**Our ref:** RA/2016/135227/02-L01  
**Your ref:** 2016/60/92664/E  
**Date:** 10 April 2017

**FRA ADDENDUM – OUTLINE APPLICATION FOR ERECTION OF 19 DWELLINGS – OAK MILL, CLIFF HOLLINS LANE, EAST BIERLEY, BD12 7ER**

**DRAWING 116/02/A2**  
**MODELLLED FLOOD LEVELS**

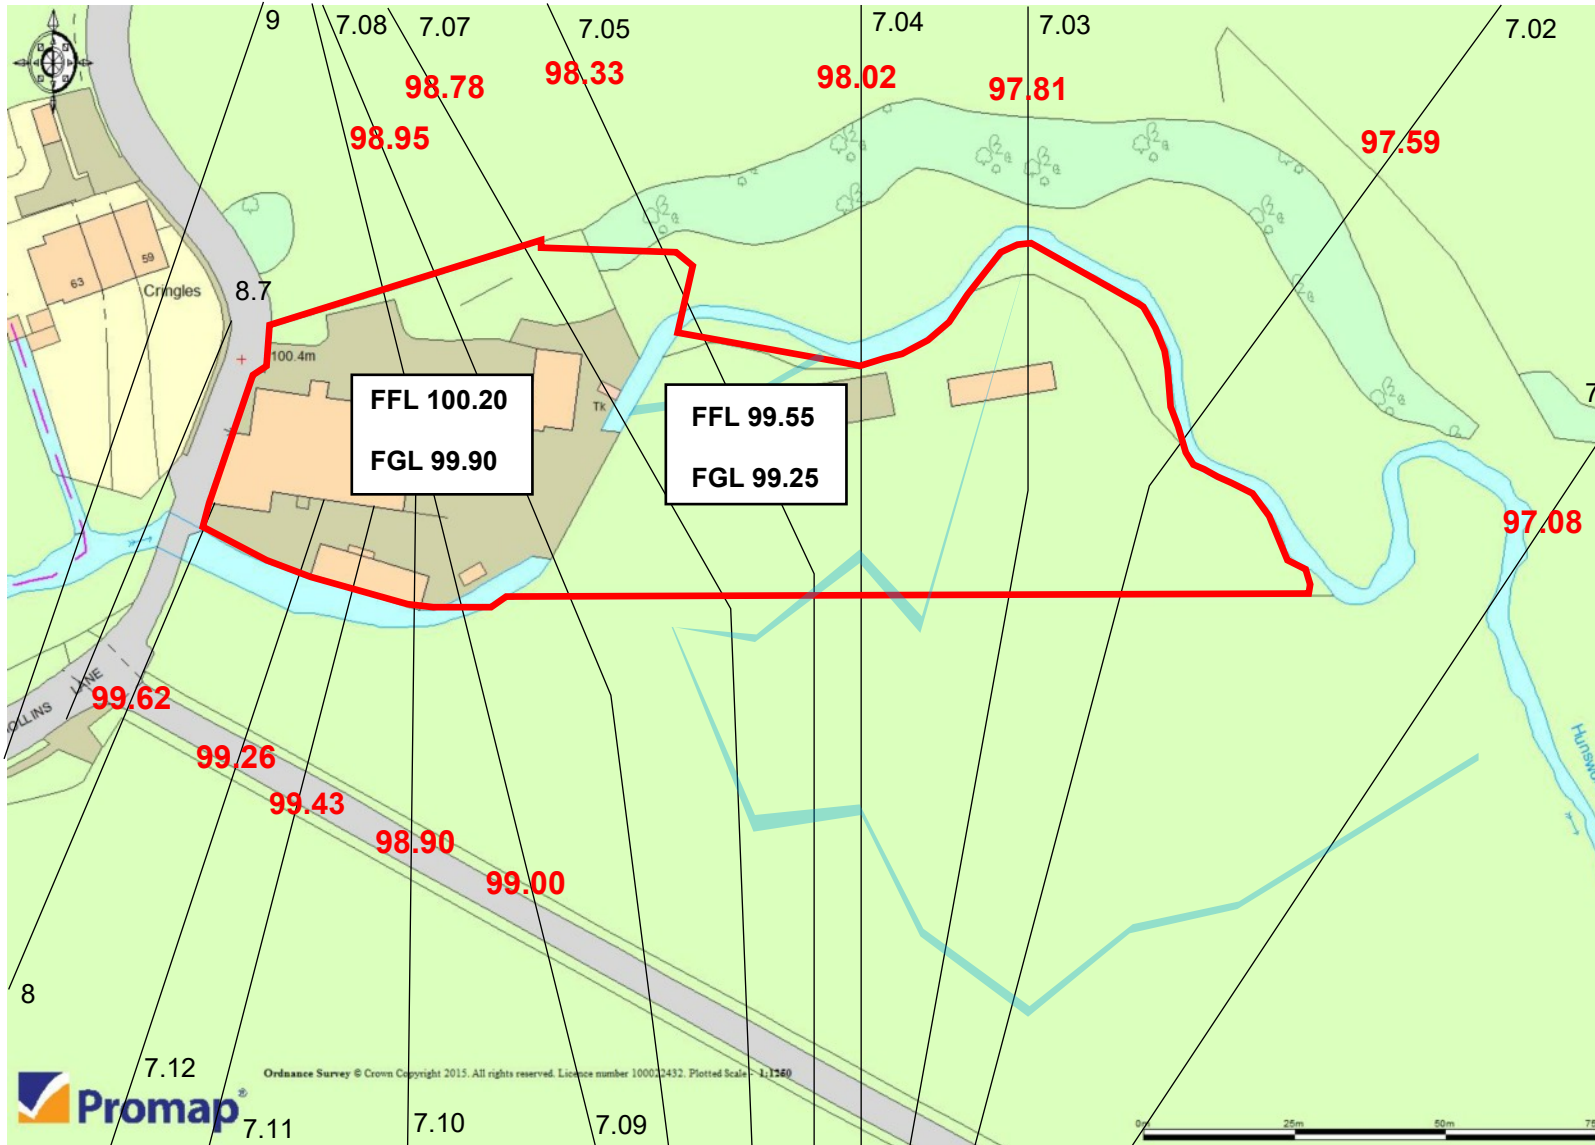
Flood mitigation measures are implemented as illustrated in drawing references 116/02/A1, 116/02/A2, 116/02/11/1015 and 116/02/11/1015 all dated February 2017.

The mitigation measures shall be fully implemented prior to occupation and subsequently in accordance with the timing / phasing arrangements embodied within the scheme, or within any other period as may subsequently be agreed, in writing, by the local planning authority.
